Fire Safety Engineering Design Review for DA Submission

327-335 Burley Road, Horsley Park
NSW (Lot 202, formerly Lot 204)

Date: 26 August 2021
Document ref: 274221.2102
Issue No: 2.0
Author: Parkan Behayeddin

DRAWING TITLE LOT 202 OFFICE PLAN A
DRAWING NUMBER 200226 - DA - 202-A110

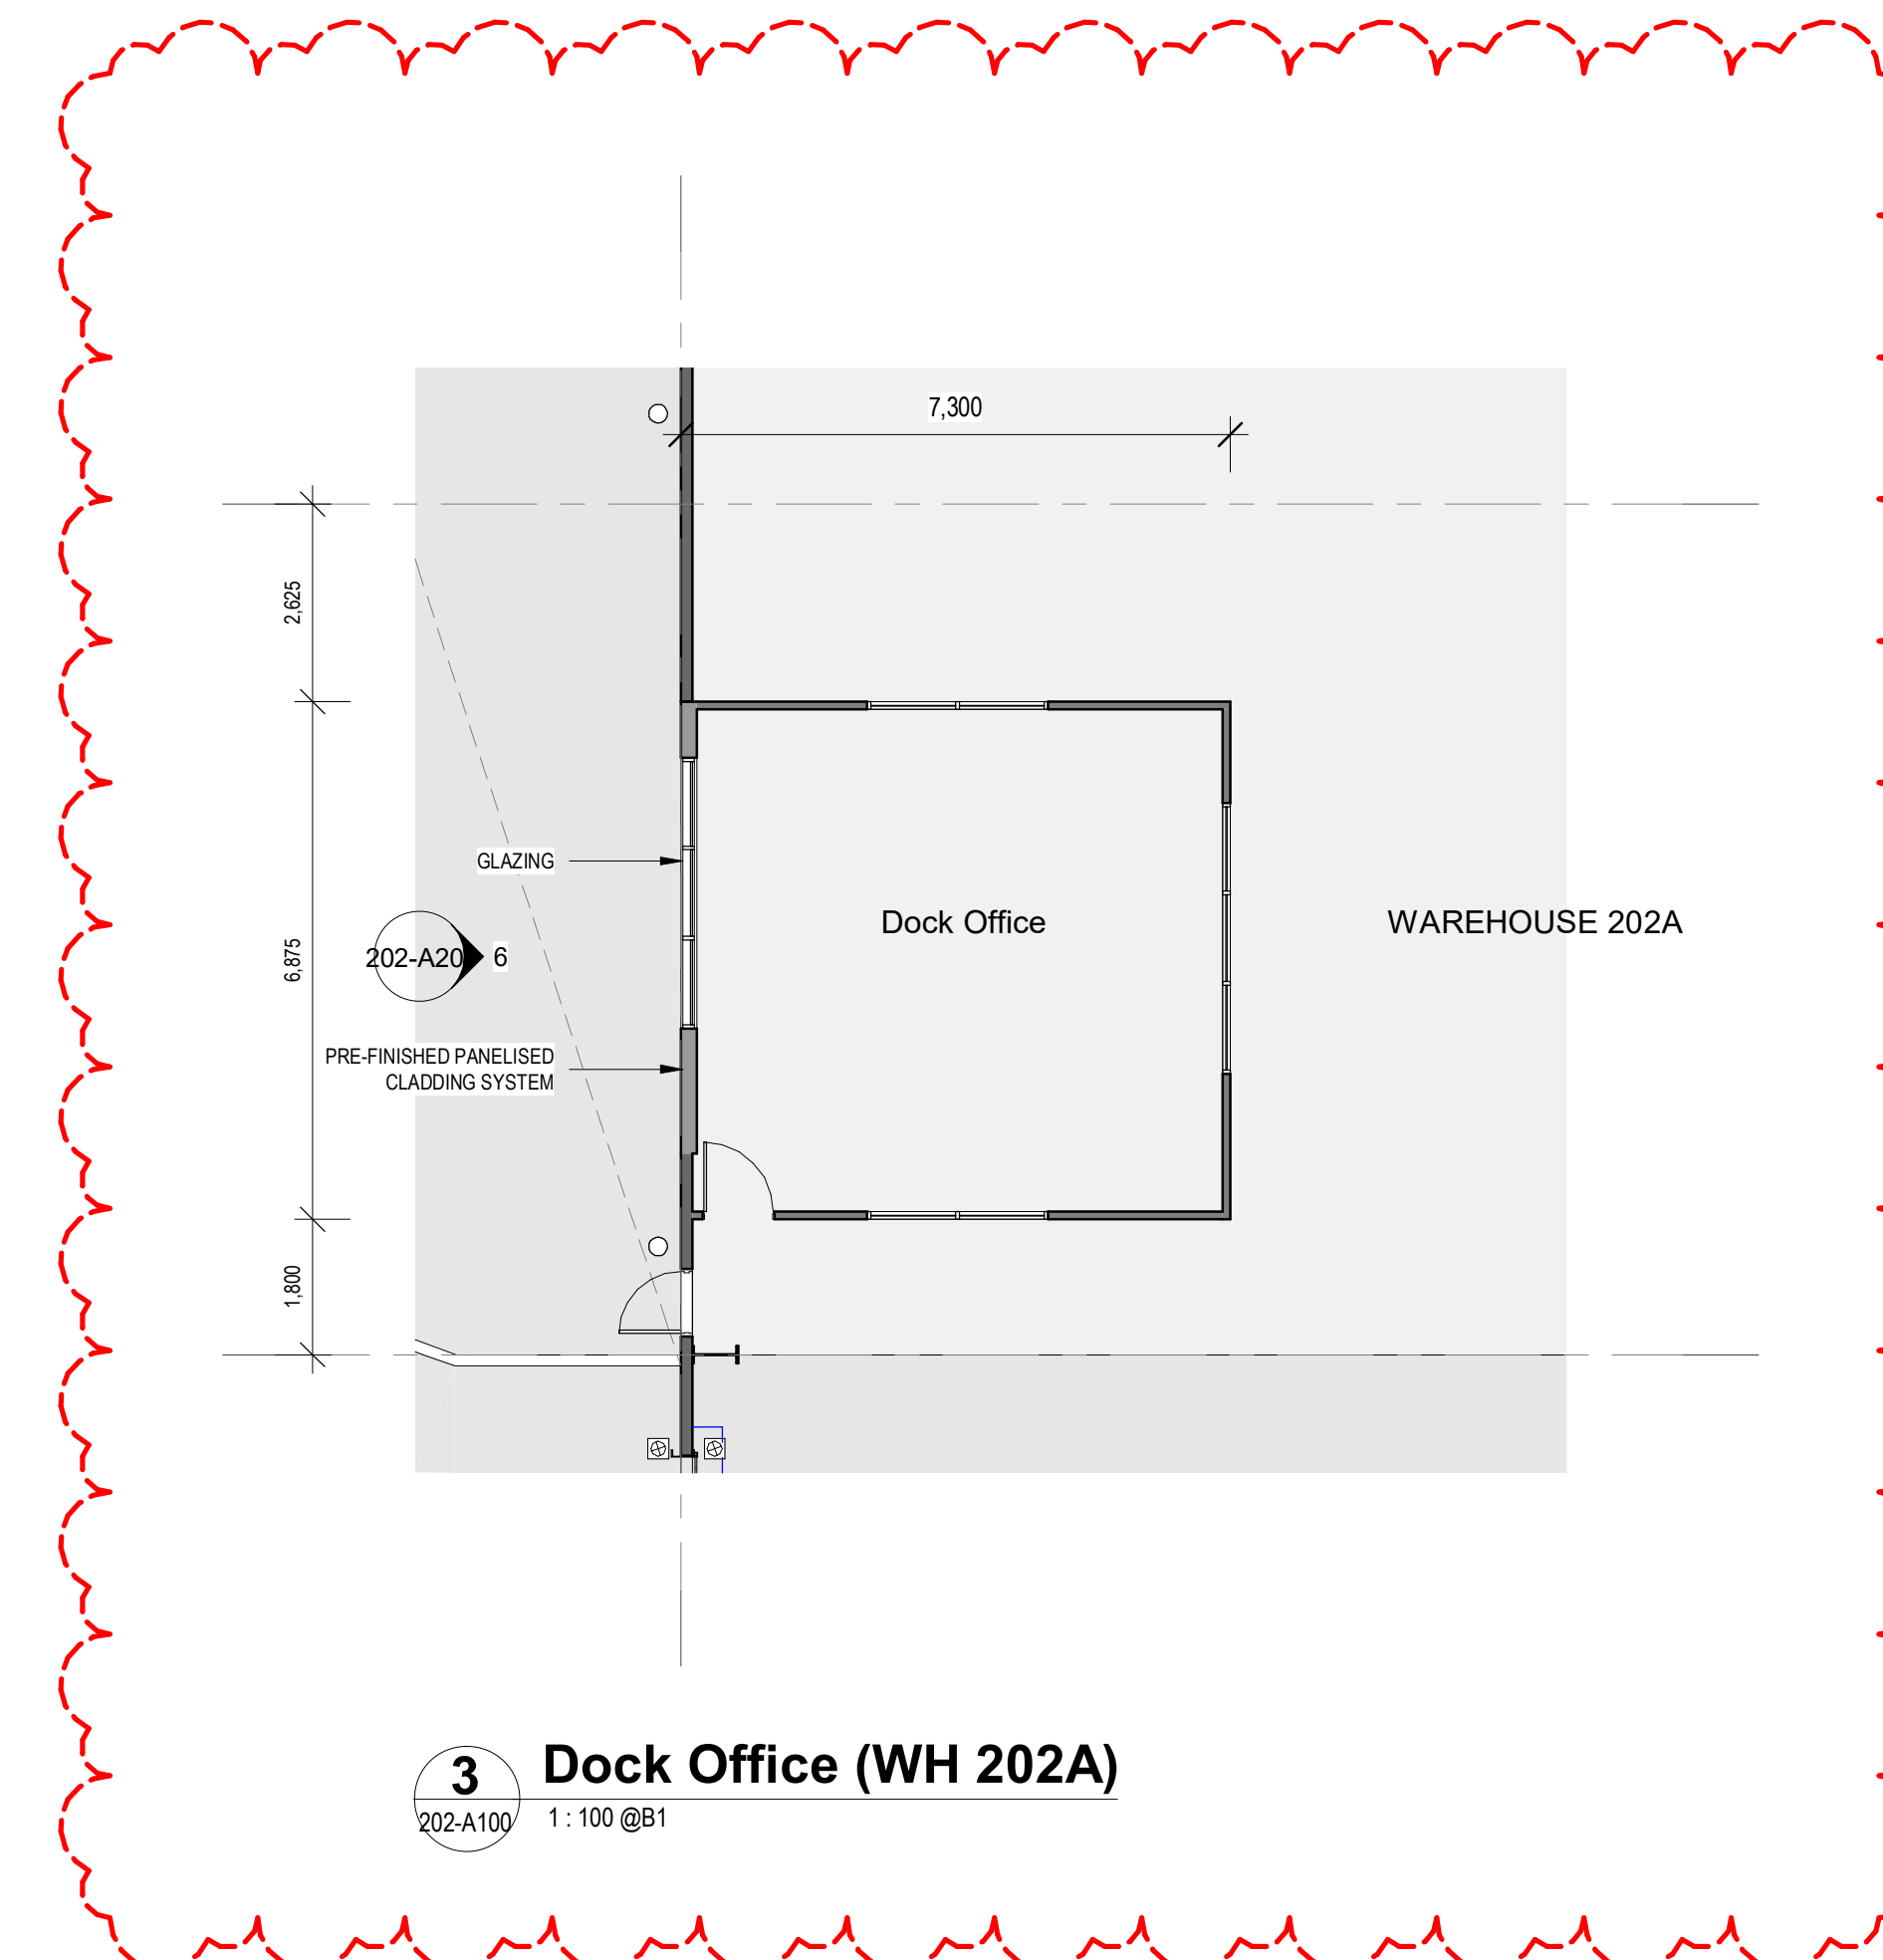
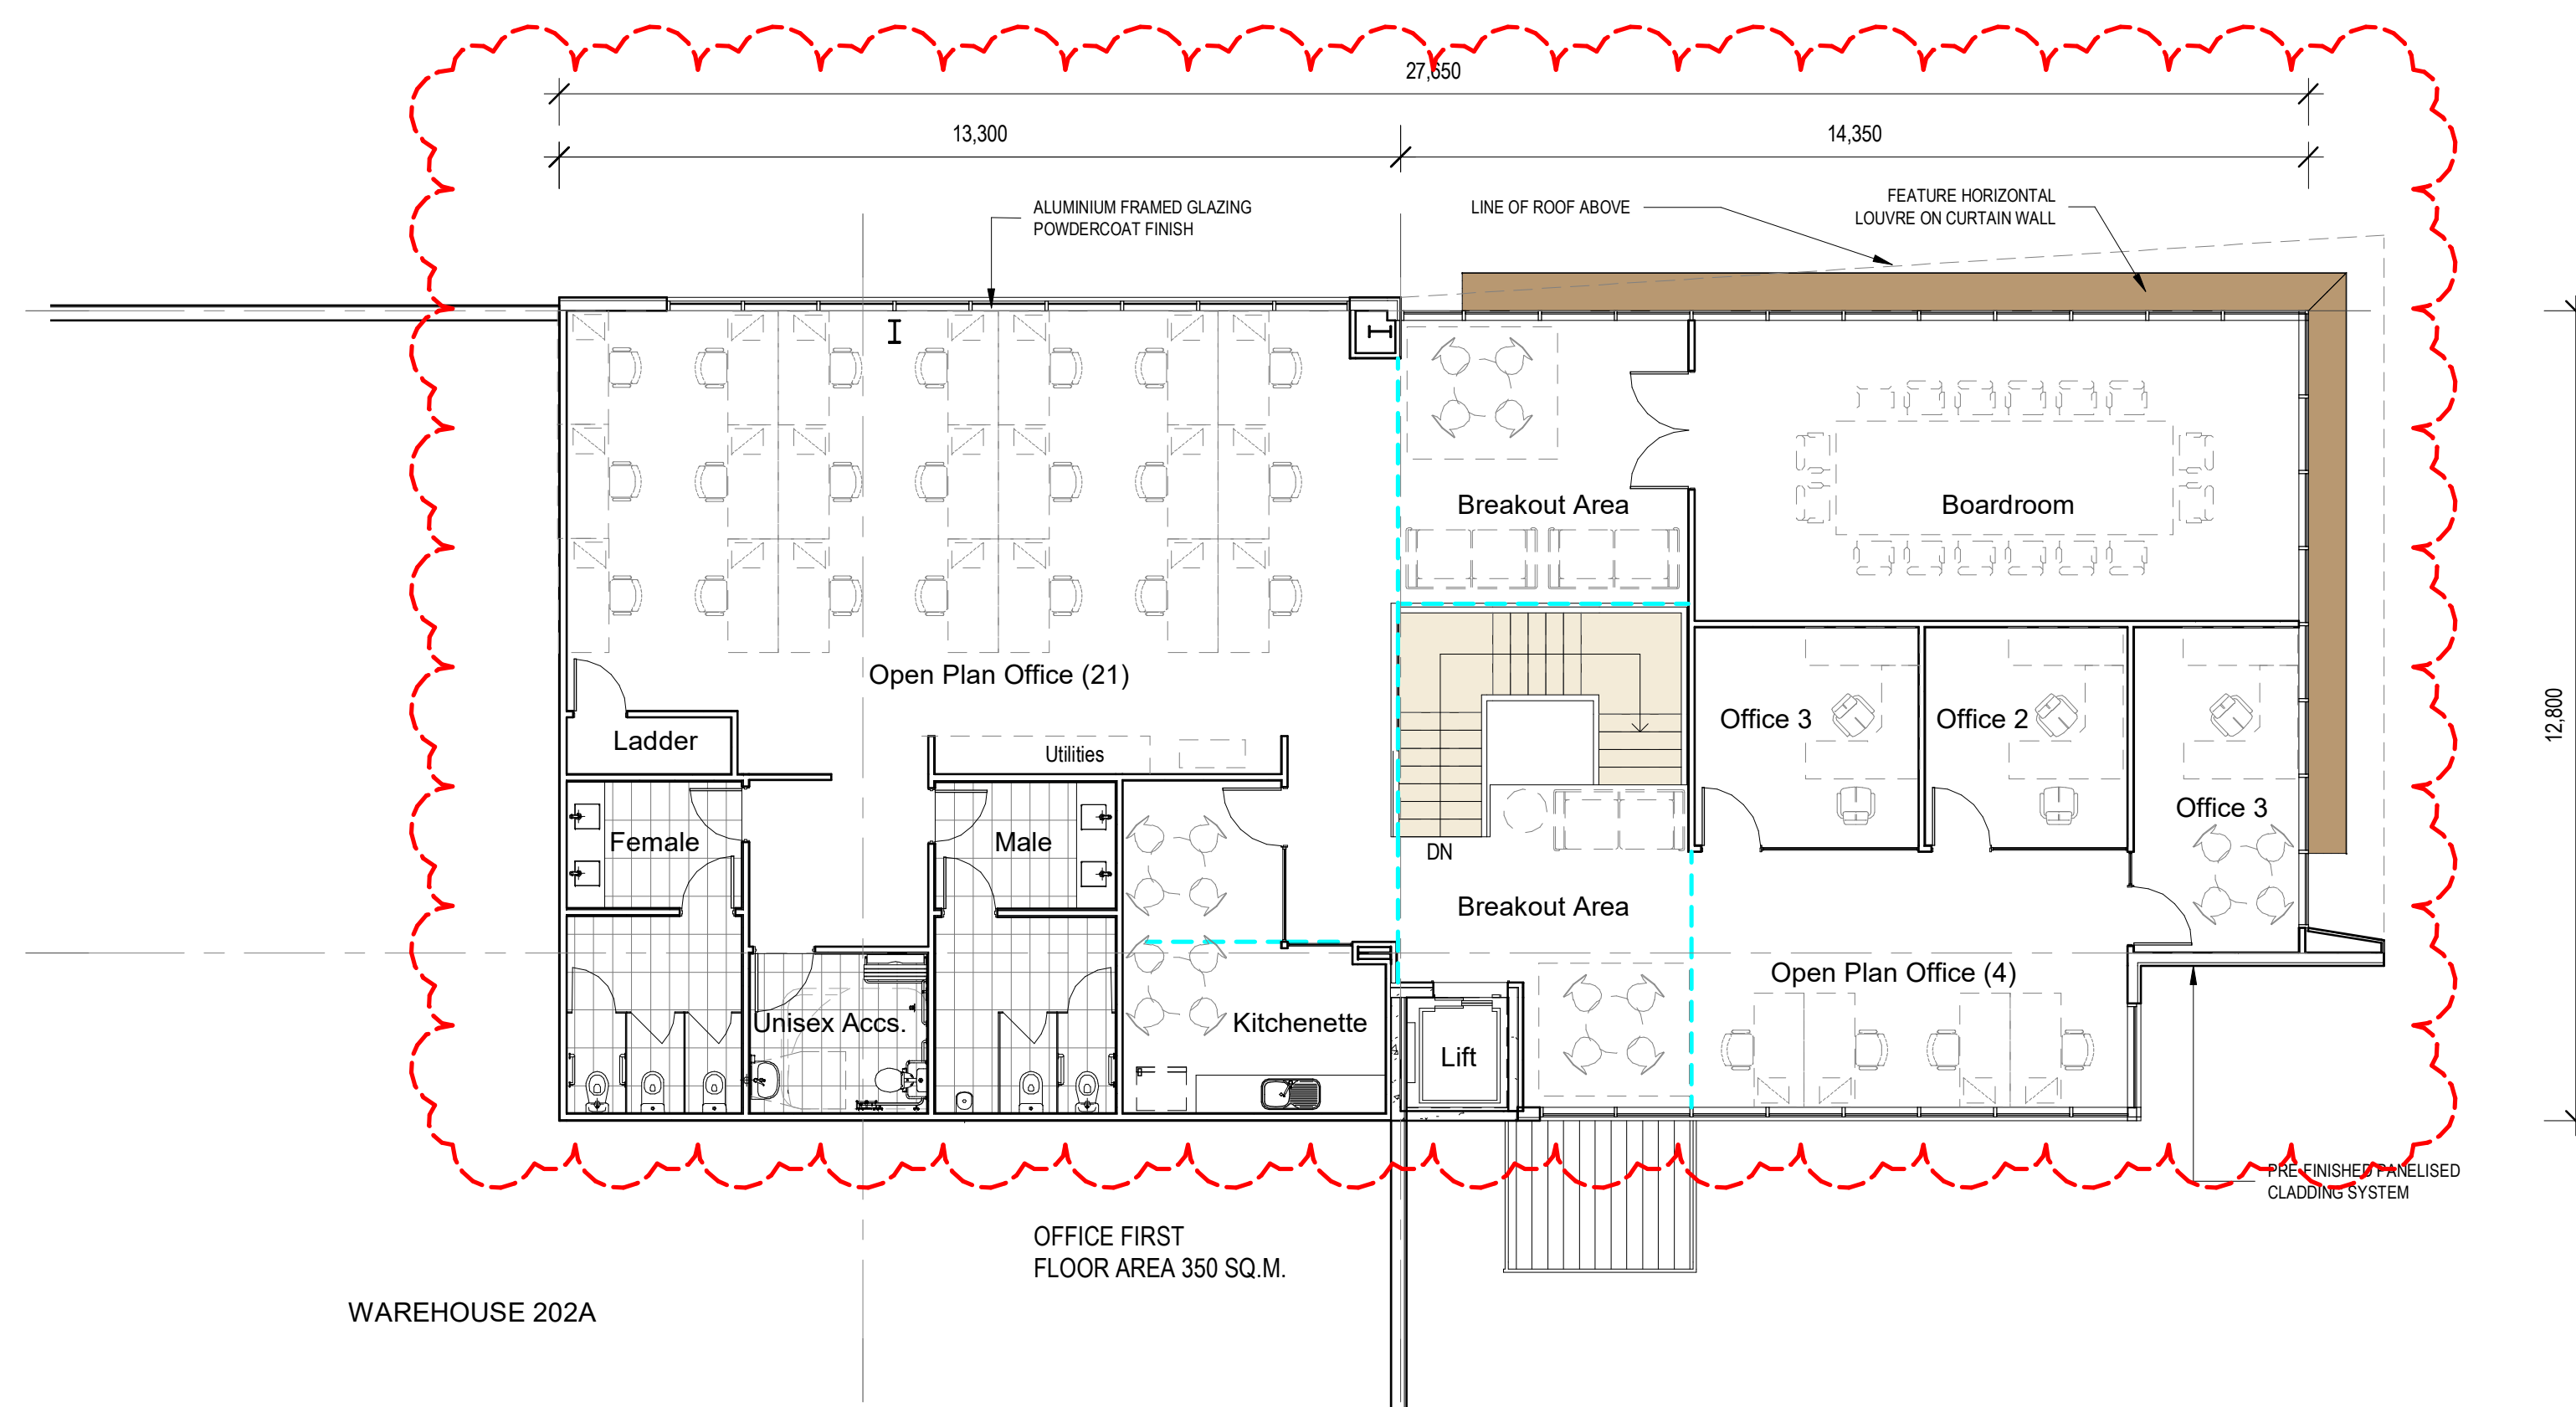
With respect to the office portions, it has been identified that the egress travel distances to a single exit (on the first floor levels) exceeds the maximum distance of 20m. To compensate for the extended travel distances, a smoke detection and alarm system shall be proposed throughout the office portions. The preliminary assessment to be conducted by Scientific Fire Services will conclude that the proposed design solution relative to occupant egress from the warehouse/processing portions shall meet the relevant *Performance Requirements*, namely DP4 and EP2.2 from the BCA.
